From: Anita Gardner
Sent: 15 July 2019 11:26
To: Lynnyrd Wolfe
Subject: FW: Scyld - Highways
Attachments: MBSK190628-01.pdf; MBSK190628-02.pdf; Highways 21.06.19.pdf

Subject: FW: Scyld - Highways

Further to the above highway comments I attach drawings showing a larger visibility splay and swept path analysis for Scyld. Mayer Brown have shown 2.4m x 90m splays which is the DMRB standard. We do not fully understand why this has been requested as our Highway Engineers are comfortable that the original 2.4m x 43m splays are acceptable in highway safety terms. Whilst we are happy to show this larger splay for indicative purposes the preference is that any condition relates to the original drawing showing 2.4 x 43m splays, otherwise this represents over engineering and sets an unusual precedent.

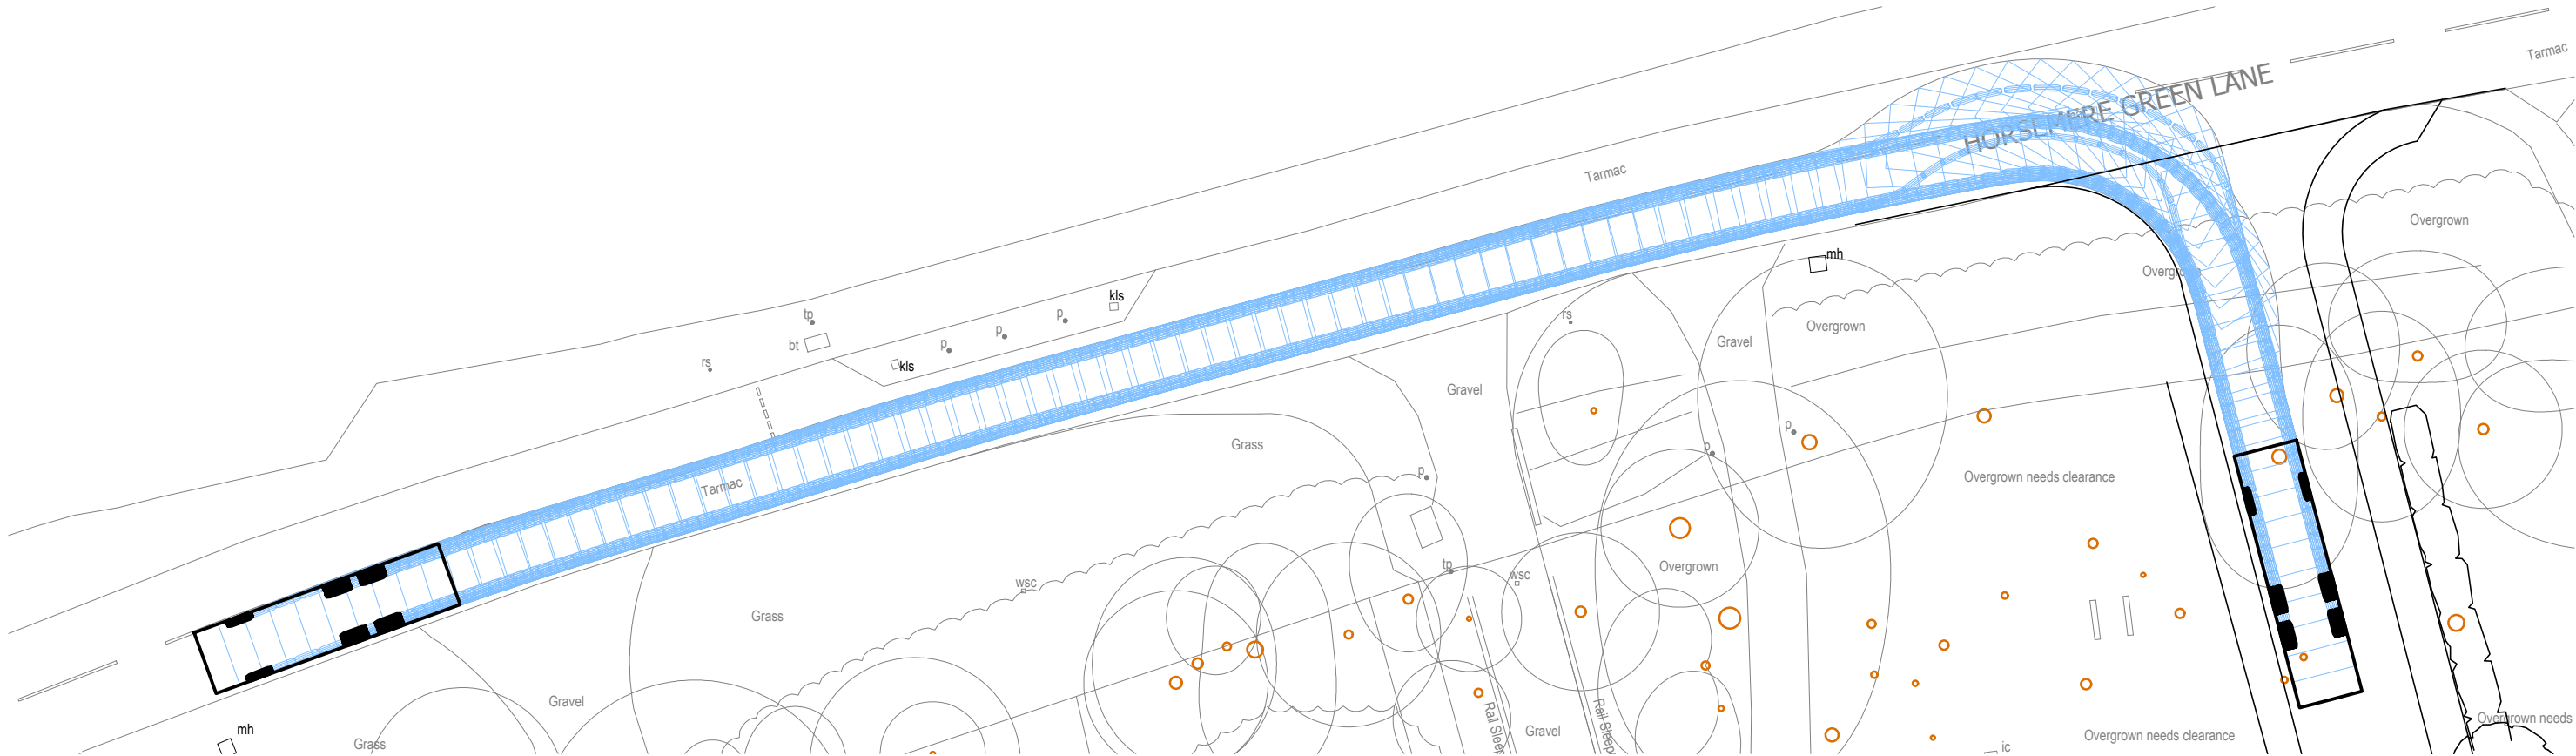
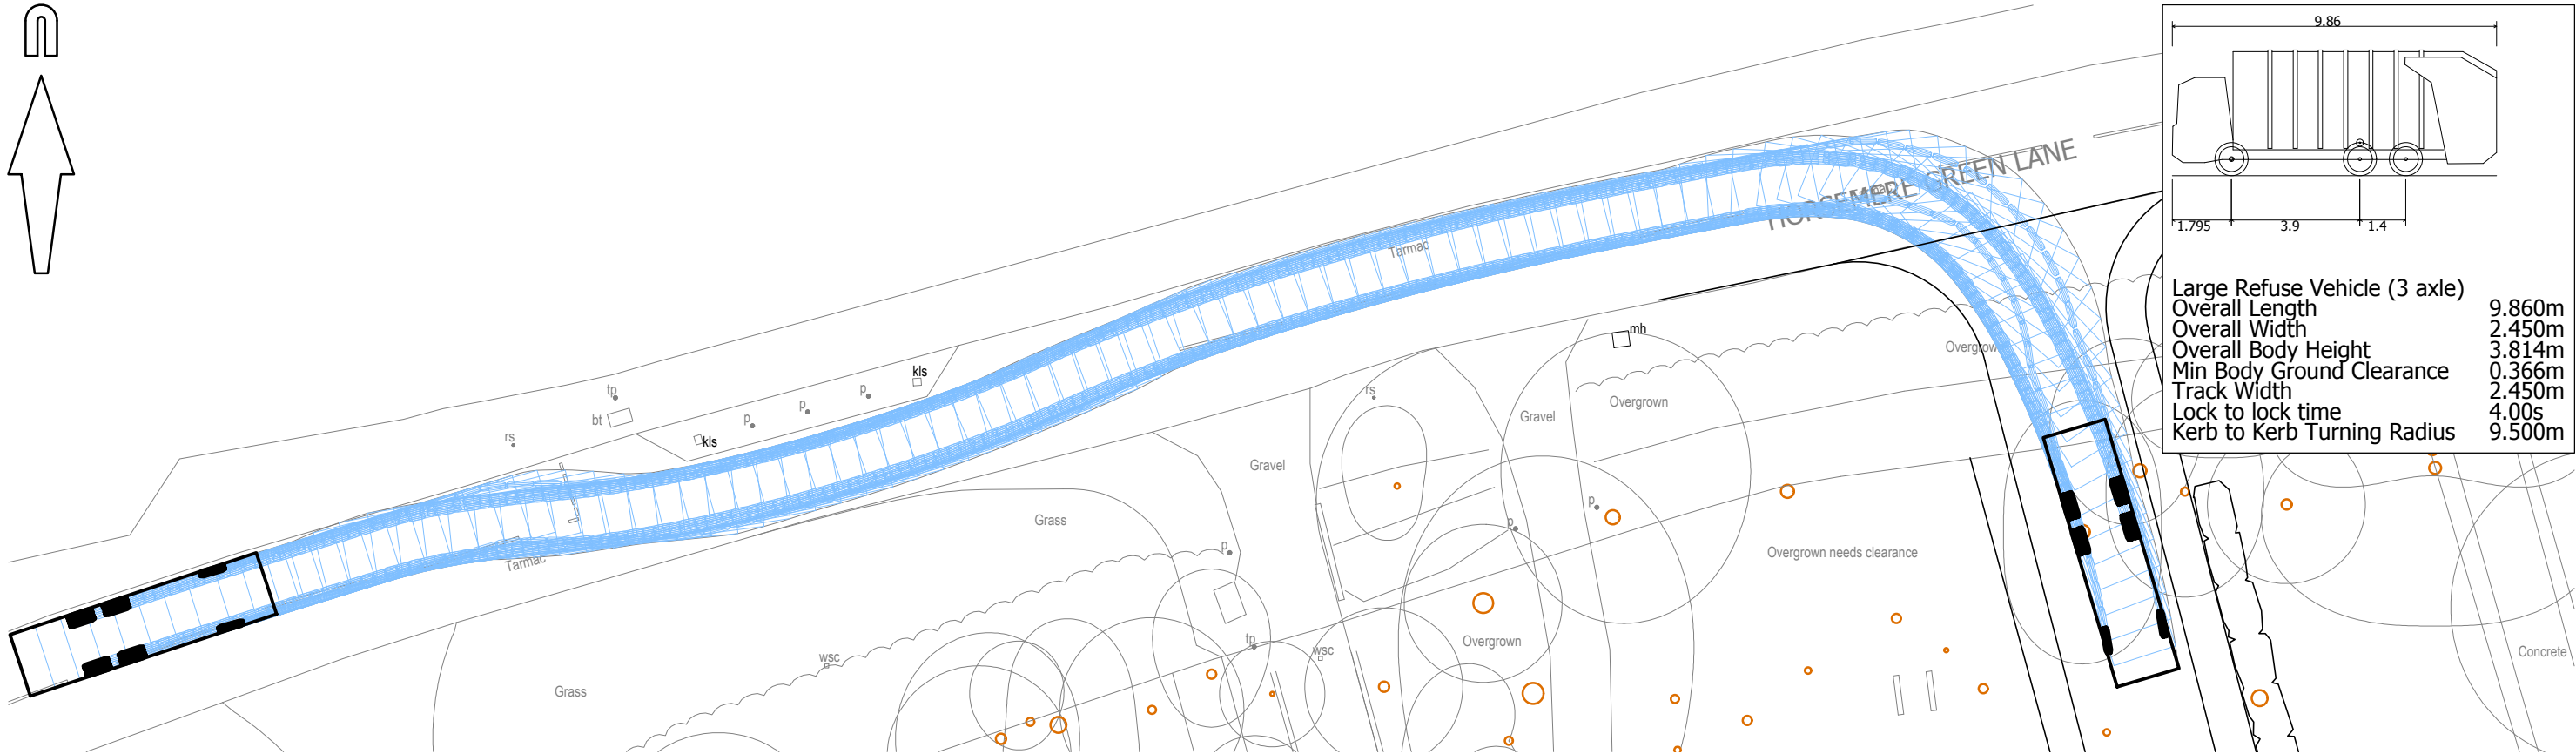
Tracking has also been provided to show that the 'build out' does not impact ingress or egress to the site.
